**Tahmoor South Coal Project (SSD 8445): Adequacy of the Environmental Impact Statement (EIS)**

the Environmental Impact Statement (EIS) for **Project Tahmoor South**, dated **21 December 2018**.

Figure 3: Conceptual Final Landform

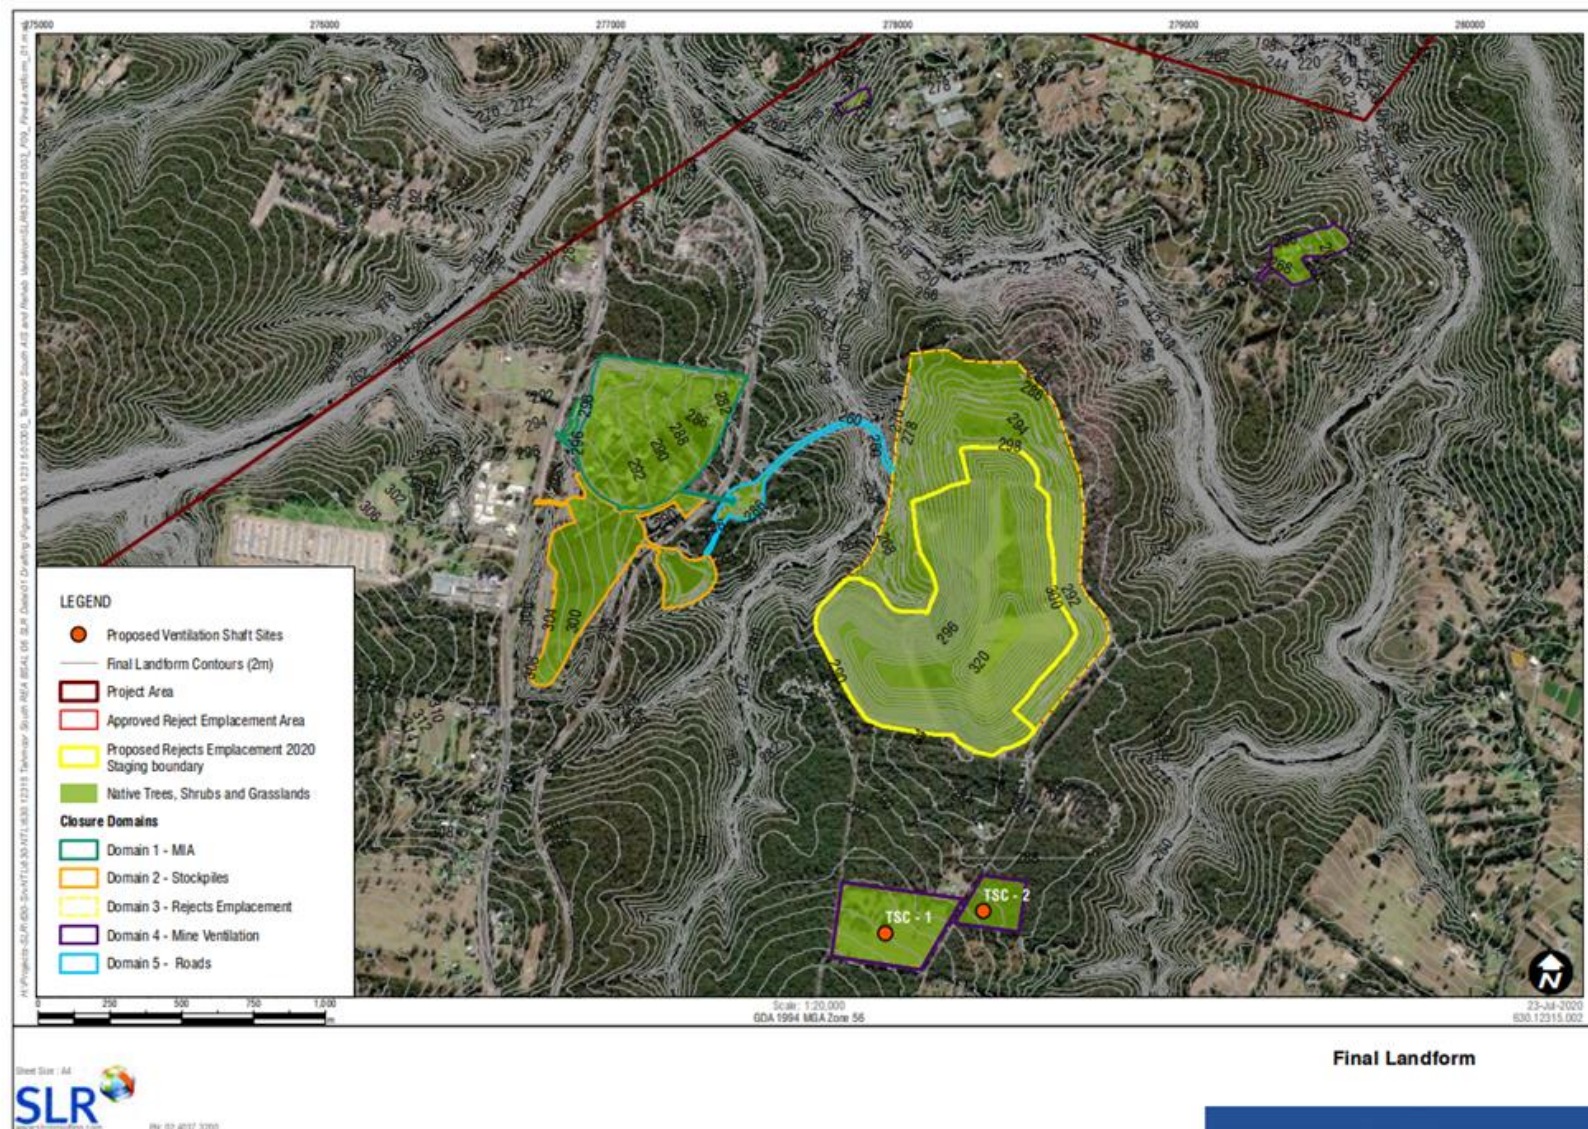
1. The "Final Landform" Plan (Figure 9 of the Conceptual Mine Closure Plan) has no contours and no indication of the Final Landform. The Plan also only covers the Reject Emplacement Area, not Domains 1, 2, 4 and 5 which would also be applicable. A more detailed "Final Landform" Plan, covering all applicable Domains, is required.
2. There is inadequate commitment to Rehabilitation of impacts to watercourses. Section 11.7.1 (Subsidence of Watercourse and Drainage Lines) refers to existing Management Plans regarding "potential impacts to streams resulting from the mining of longwalls" but these are not provided as part of the EIS and there is inadequate information provided to give confidence that remediation will occur to a satisfactory standard.
